Please ask for: Ms Iqraa Malik
Email: iqraa.malik@terraquest.co.uk
Telephone: 01212341390
Our Ref: BR/272/20/HH
Your Ref:
Date: 17th November 2020

Development: Conversion of garage to habitable use include a single storey side extension and single storey link extension from existing dwelling to converted garage
Location: 12 Parkway Bognor Regis PO21 2XR

I regret that I am unable to accept your documents as a formal application until the following item(s) have been received or resolved :-

BLOCK PLAN 1:500

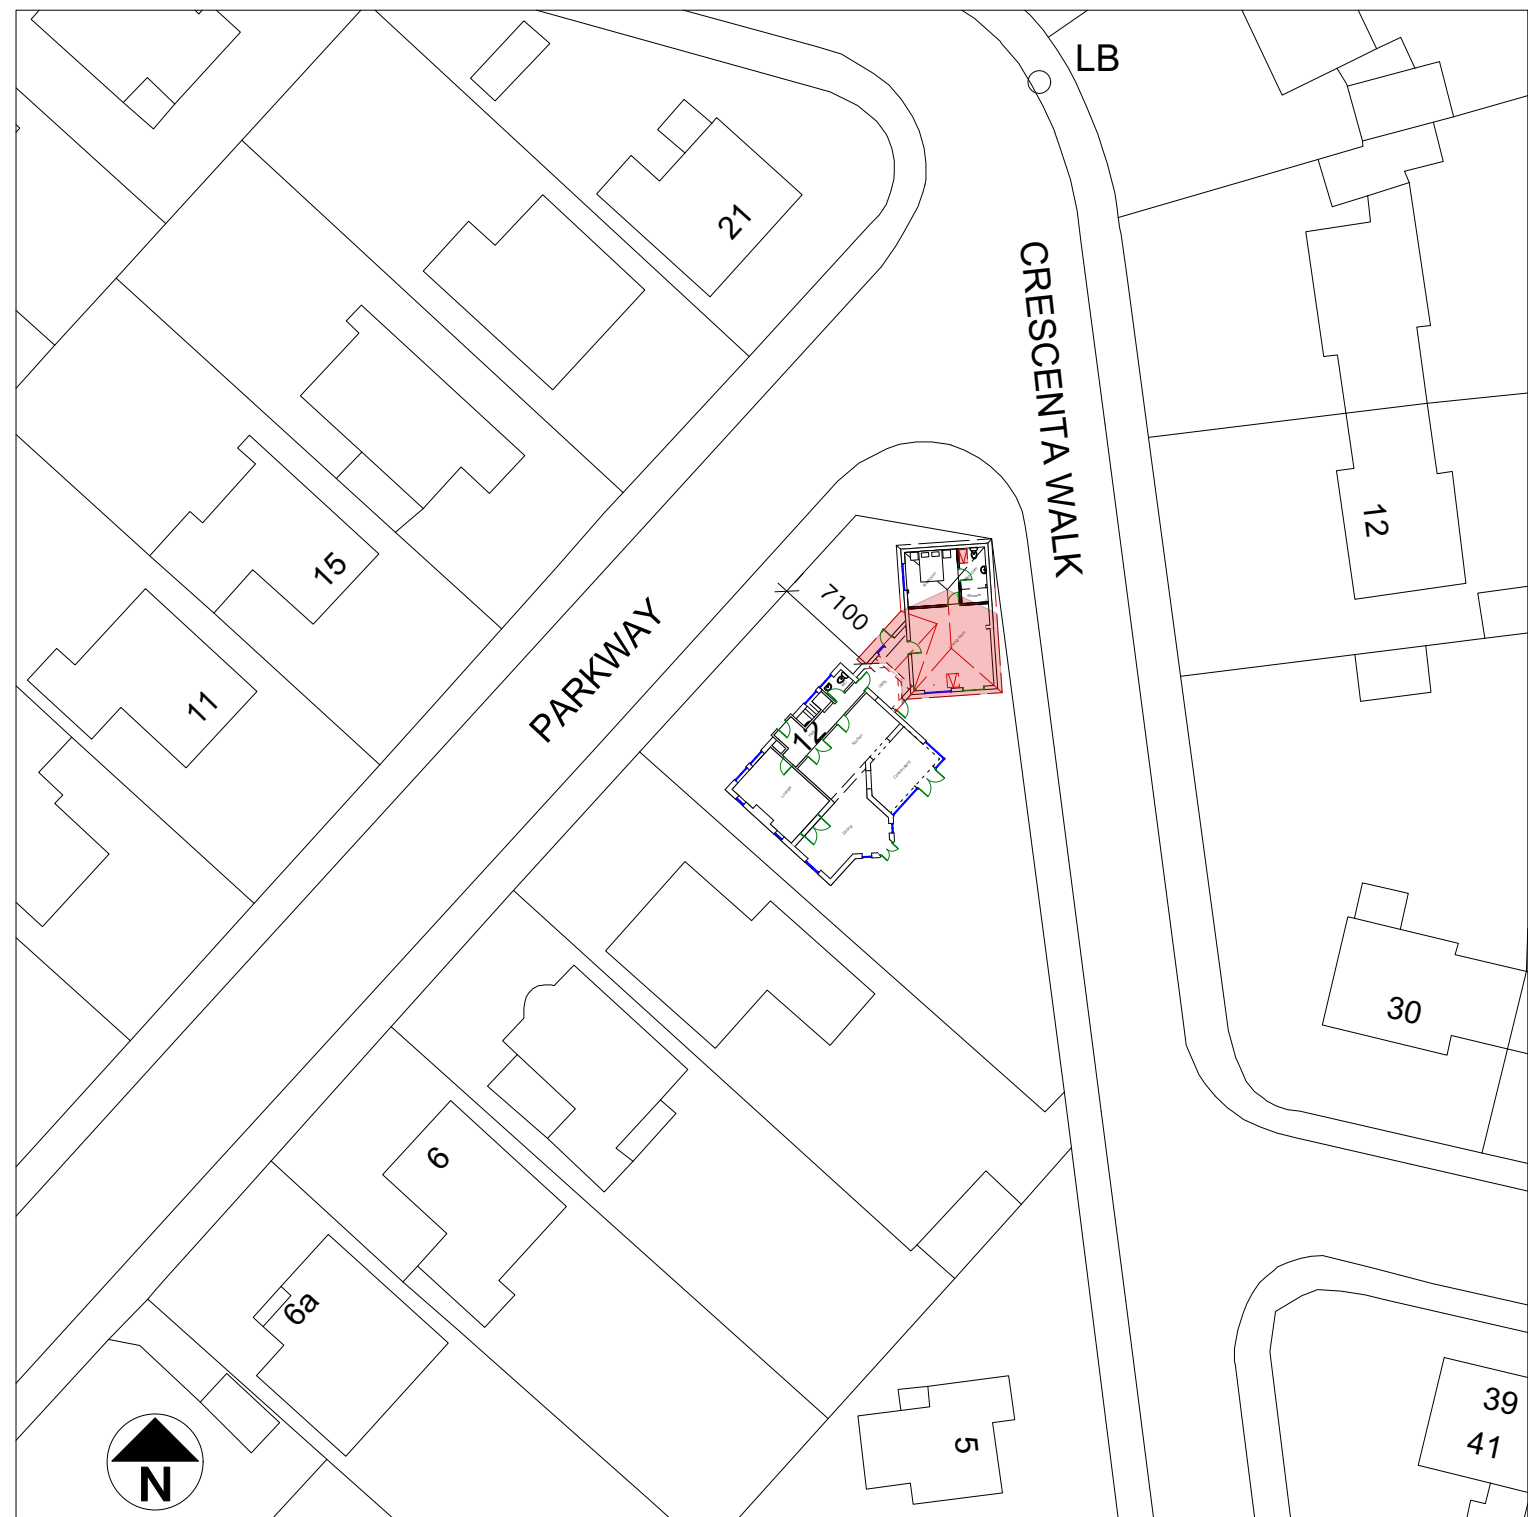
Dimensions: You are required to include dimensions from the proposed extension to all site boundaries on the proposed block plan
